From: Meachen, Tracey
Sent: 14 August 2015 18:06
To: _planningadvice
Subject: FW: H14-0643-15: 1 Benner Road, Pinchbeck, Spalding
Attachments: Timber racking 1.jpg; agg bays B2.jpg; agg bay 3 B2.jpg; Displays.jpg

From: Meachen, Tracey [<mailto:TMeachen@sholland.gov.uk>]
Sent: 11 August 2015 15:04
To: 'steve@stevendunnarchitects.co.uk'
Subject: H14-0643-15: 1 Benner Road, Pinchbeck, Spalding
Importance: High

CLIENT
Parkland Developments
DRAWING TITLE
Proposal Site Layout Block Plan

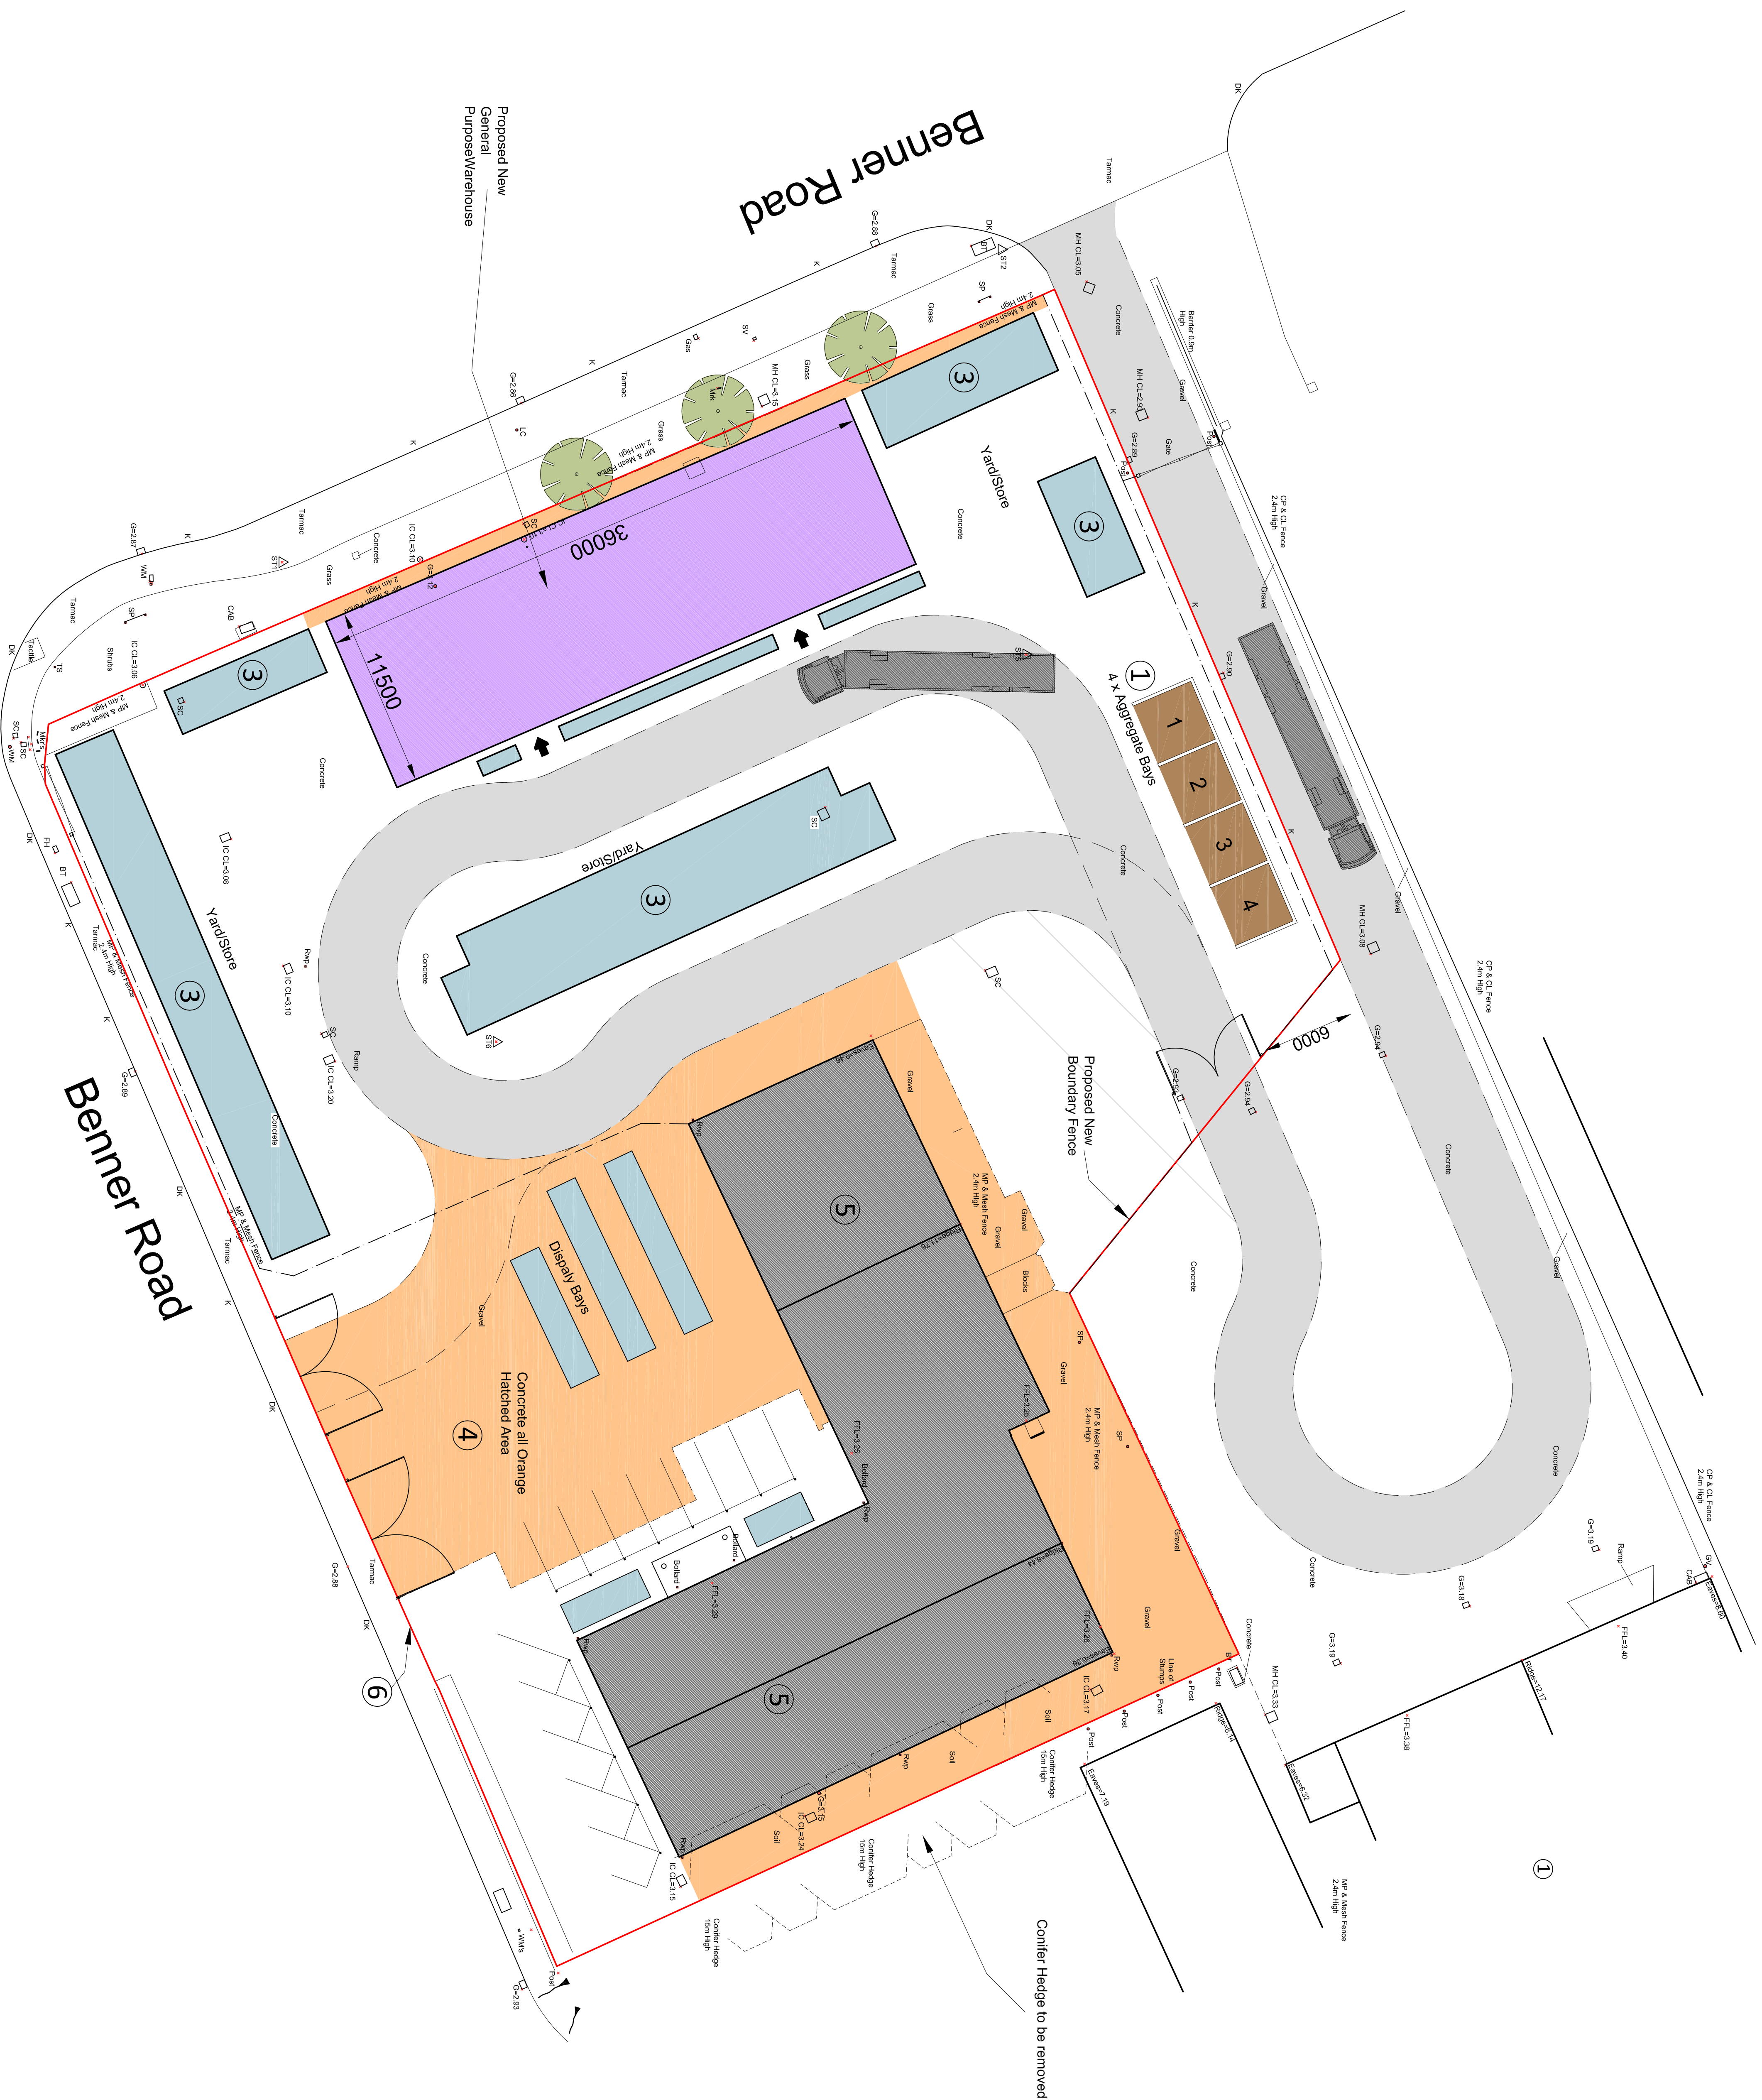
I would also require further details on the height and appearance of the proposed aggregate bays (4) , display bays, and storage racking (3).

Timber racking size 2600mm high

Aggregate Bays are 2.180mm at the back, 1.7mtr at the front

Displays are 1.2 mtrs high
